From: Martyn White
Sent: 28 August 2020 16:52
To: Planning.Responses
Subject: AL/49/20/PL

Byfields & Nightingale Cottage Nyton Road Westergate PO20 3US

Demolition of 2 No existing dwellings & erection of 7 No. dwellings with associated parking, bin store, alterations to the existing access & extension of the existing footway.

Client: Elizabeth Halton	
Project Address: Byfields and Nightingale Cottage Nylon Lane Westergate West Sussex	
Drawing Title: New Dwelling at Nightingale Cottage Proposed Plans, Elevations and Roof Plan	
Drawing Number: 1243.04	
Scale:	As stated printed @ A1
Date:	22/04/2020

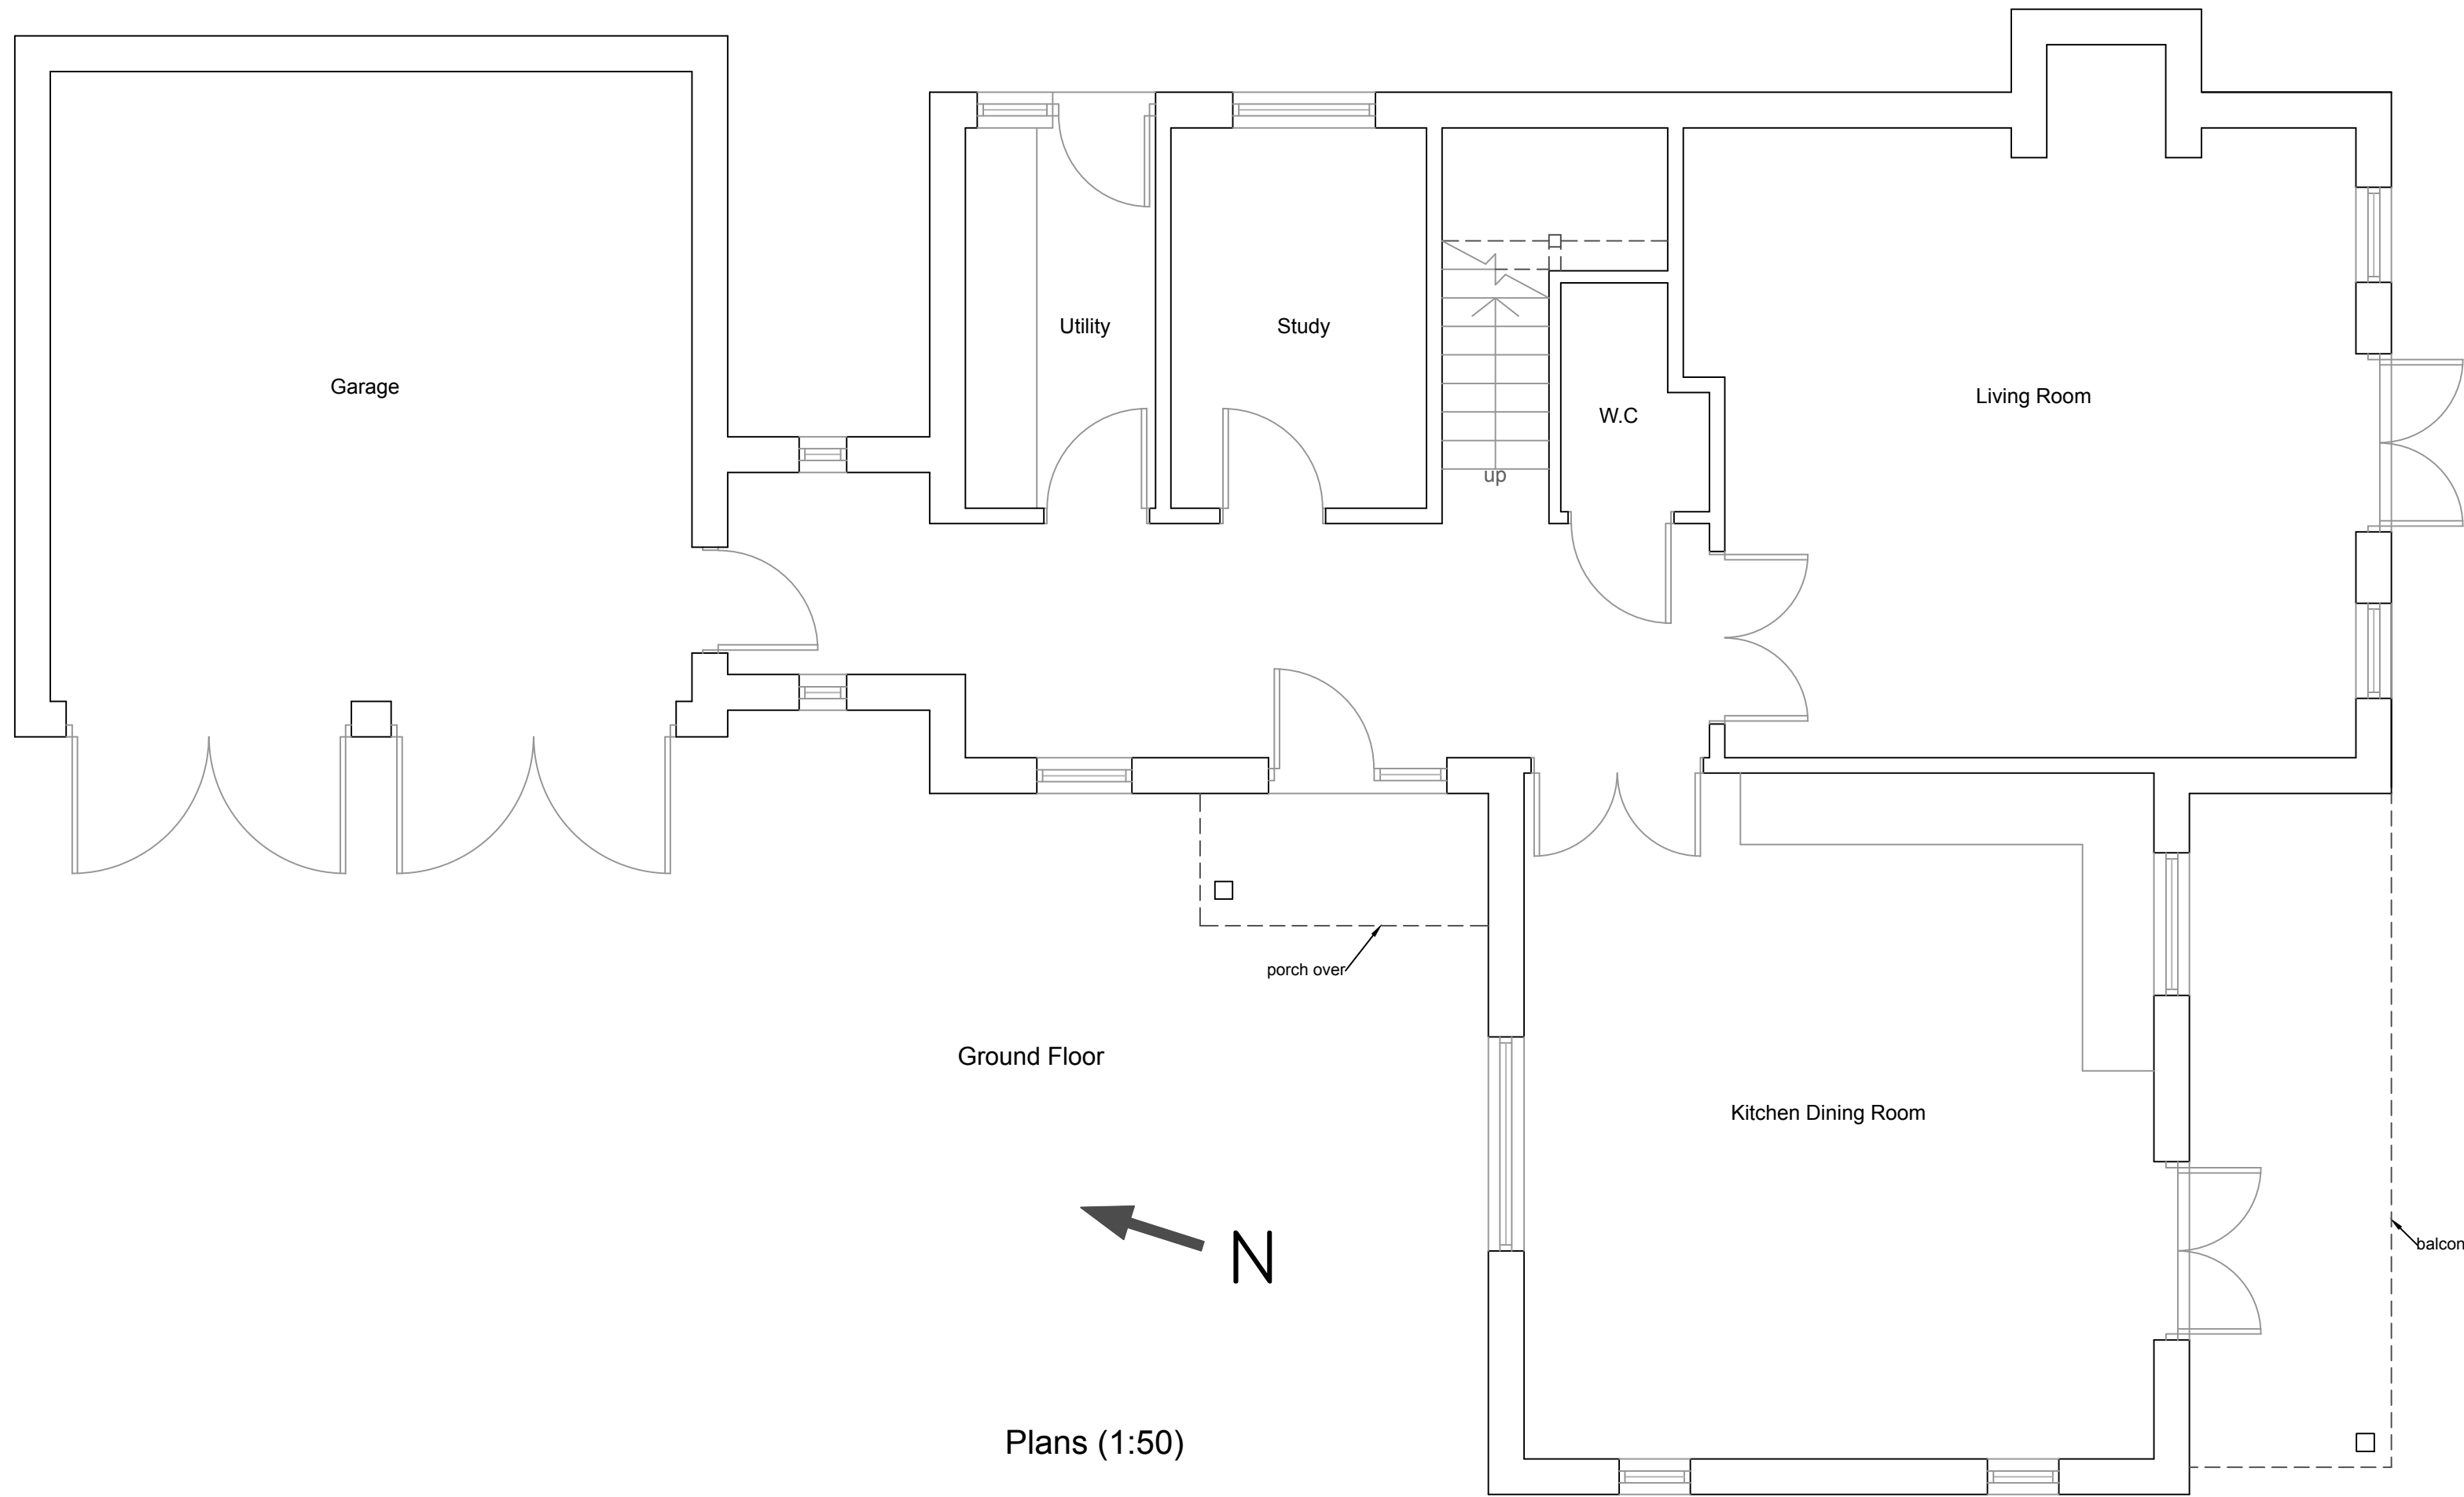
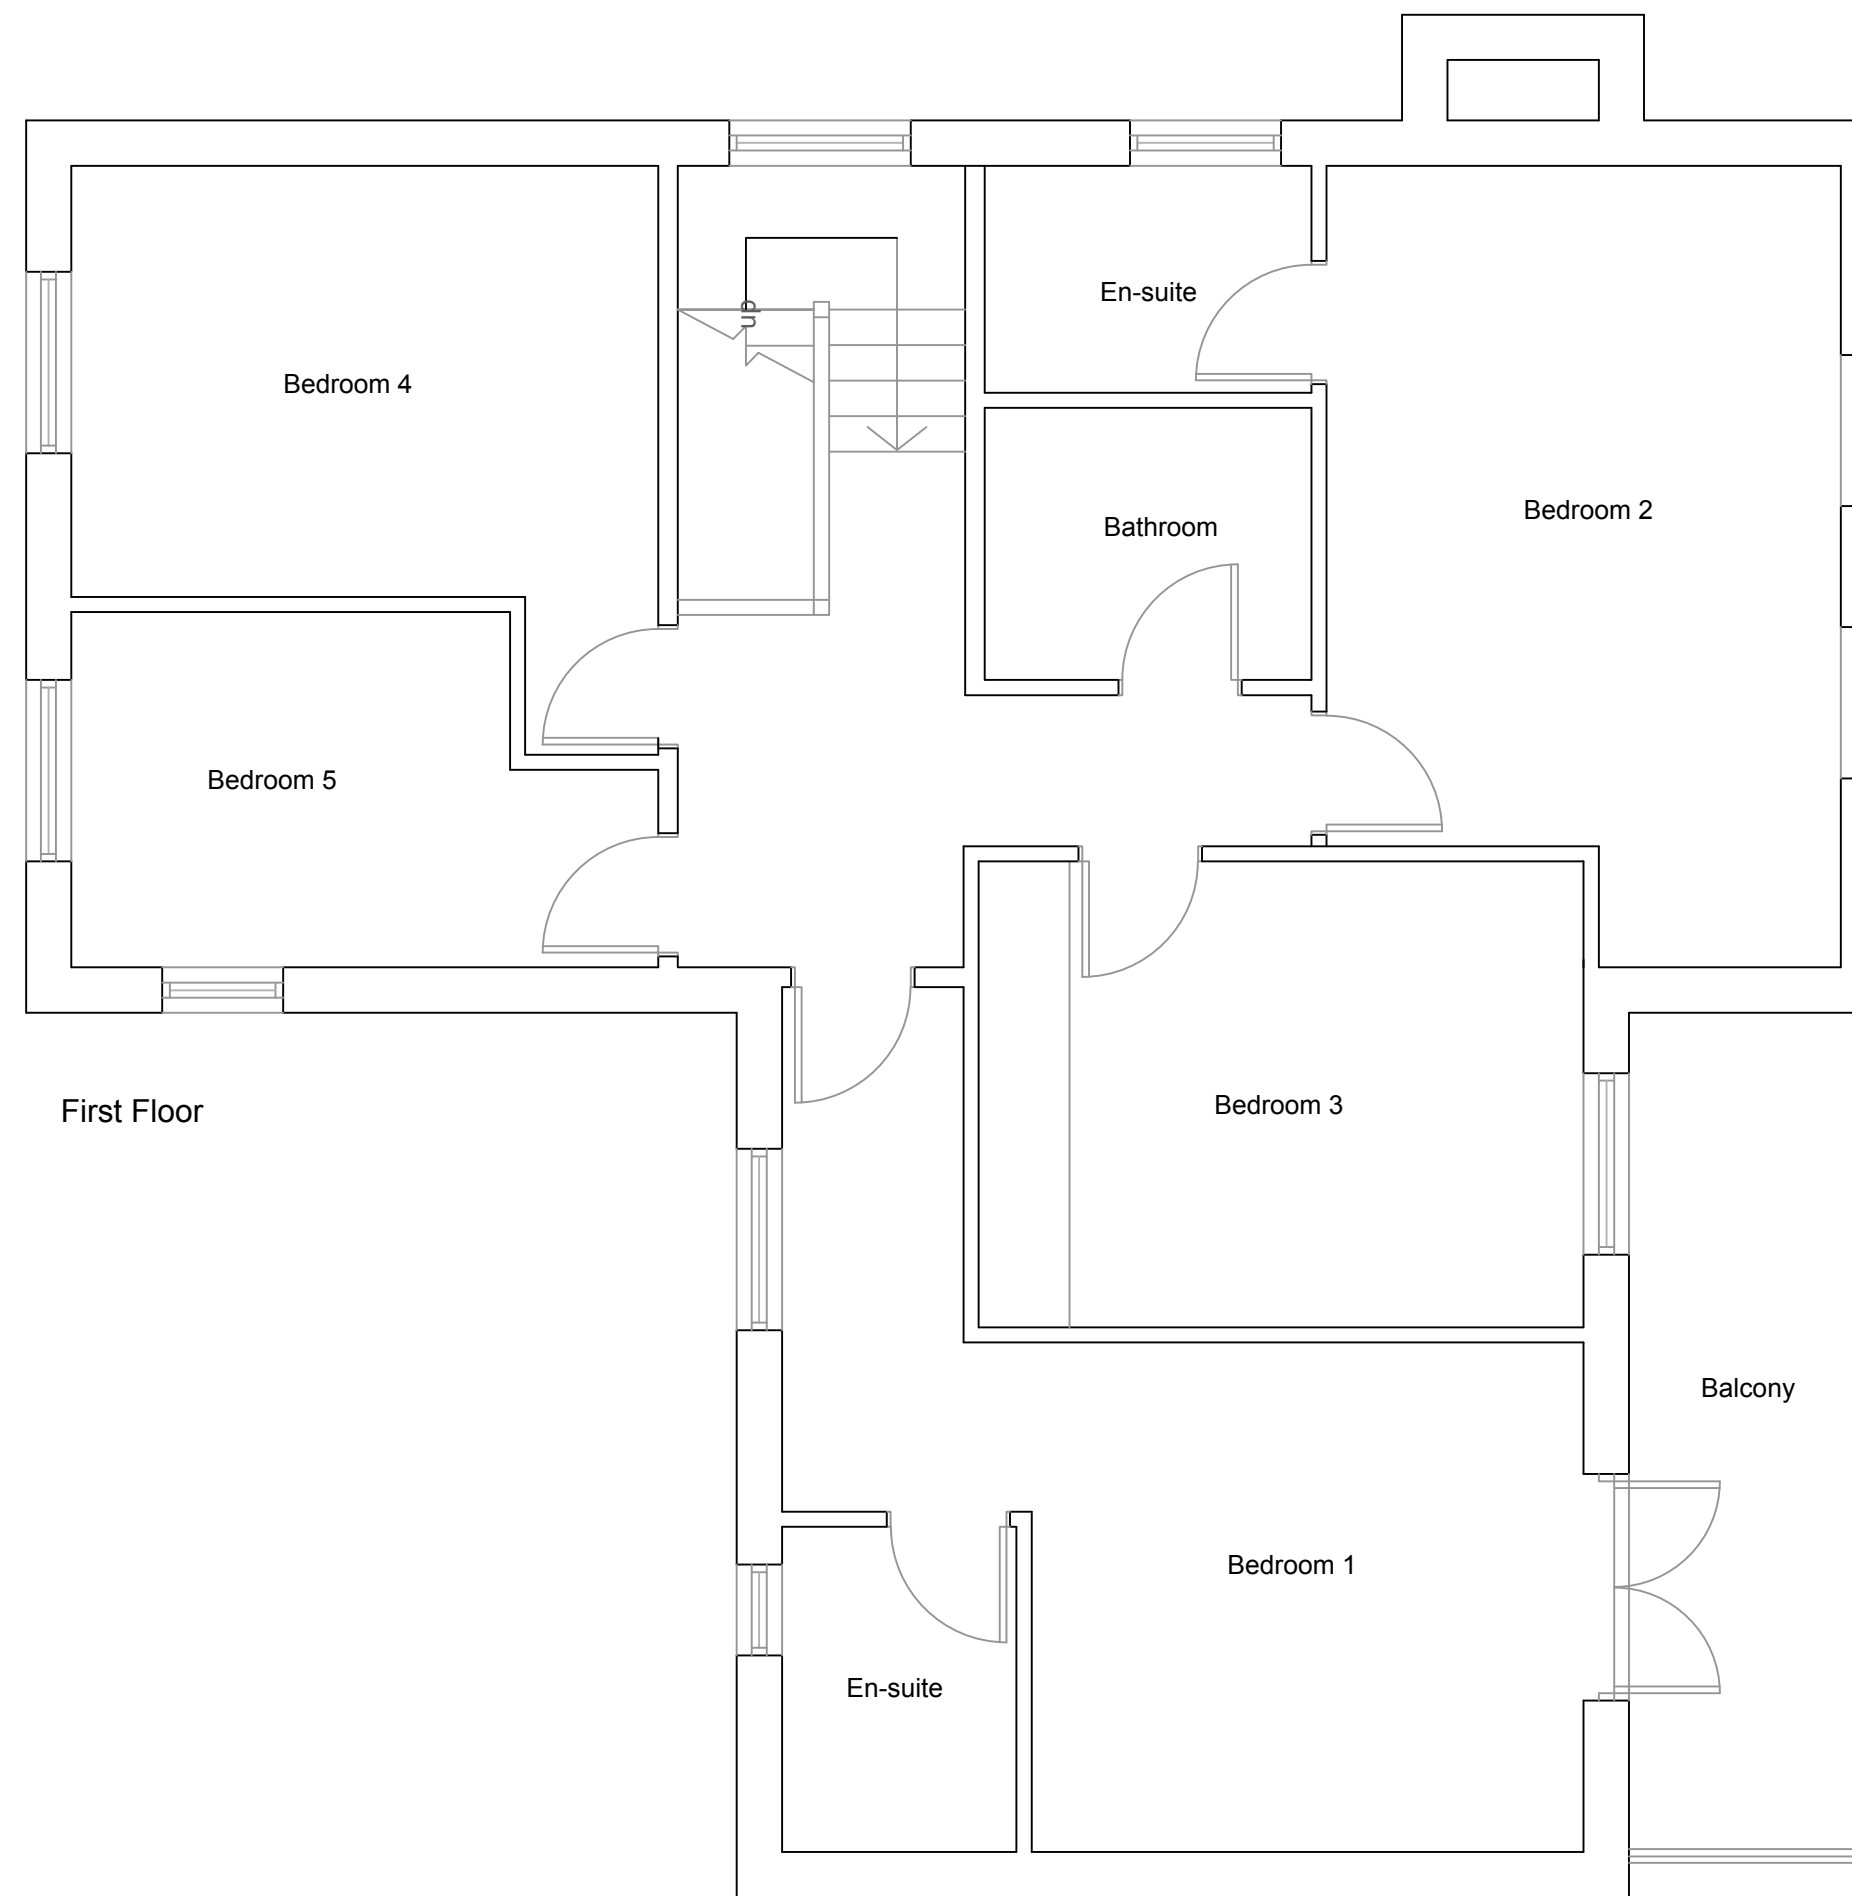
The loss of the building is therefore unfortunate and problematic as it would lead to the loss of a pleasant building which is visible on the street-scene. At present, it is not clear why the existing building and flint walled area (attractive former building) cannot form part of a new development. The replacement building would be visible in the context of the listed building, and it is not clear how the local, traditional buildings (including the listed building) have informed the design of the new house, which does seem somewhat of a standard design. It is considered that the site offers the opportunity for new development to better reveal the buildings and character of the local area, and it is a shame that this isn't the case with this application. The loss of the existing building and its proposed replacement is therefore considered to be harmful.
